Replacement of tile hanging with black PVCu cladding to 2 No. bay windows. This application may affect the setting of listed buildings & may affect the character & appearance of the Upper Bognor Road & Mead Lane Conservation Area.

22-24 Oakhurst Upper Bognor Road Bognor Regis

Thank you for your internet representation made on 3rd September 2019 which has been recorded as '**an objection**' with the comments as follows:

C		
B		
A		
Client	H.D. Buschhaus Esq.	
Address	22-24 Upper Bognor Road : Bognor	
Drawing	EXTERNAL ALTERATIONS	No. 4919:1
Scale	1:100	Drawn 2 Date 00/1/19

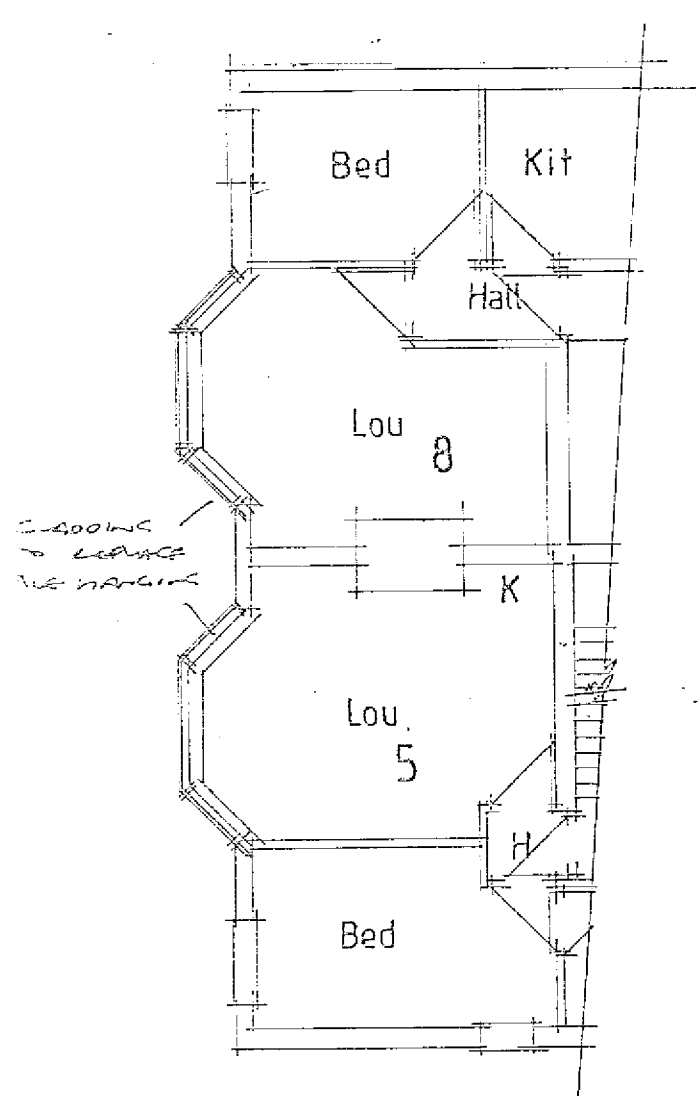
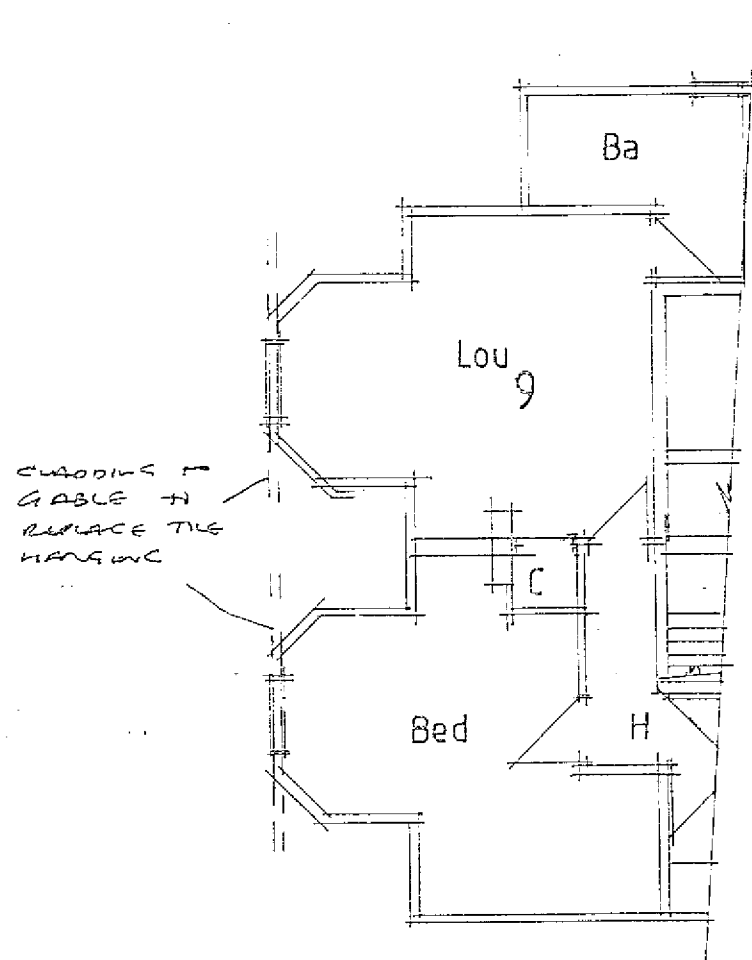
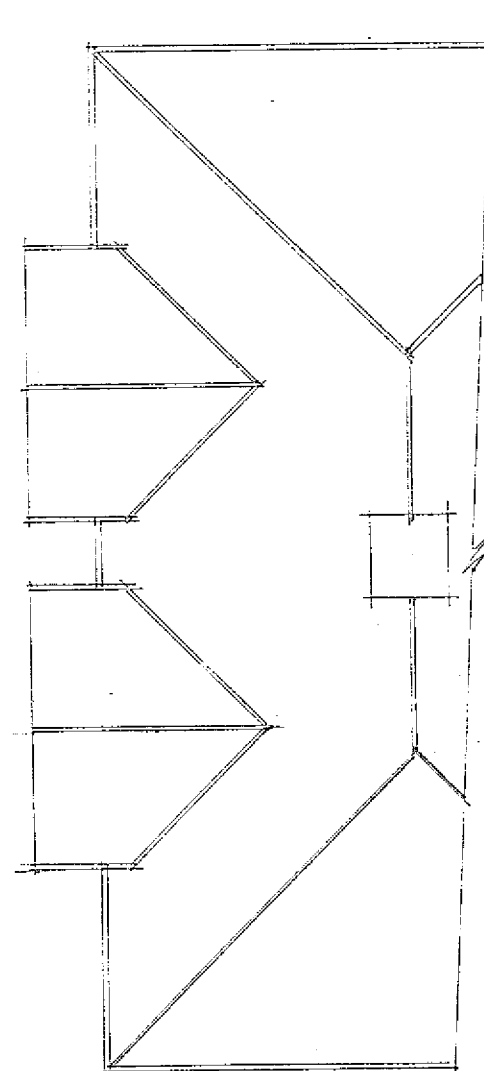
The building is local listed and by reason of its style, age and position it makes a positive contribution to the character and appearance of the Conservation Area. The introduction of PVCu cladding, replacing traditional clay vertical tiling, would detract materially from the character of the building and thereby also detracts from the appearance of the Conservation Area.

The proposal therefore conflicts with the relevant paragraphs of the NPPF 2019, paragraph 192 (heritage assets - includes Conservation Areas) and paragraph 127 (design quality) as well as the Arun District Local Plan 2018, policy HER DM3 (Conservation Areas), policies DSP1 and DDM1 (design quality)
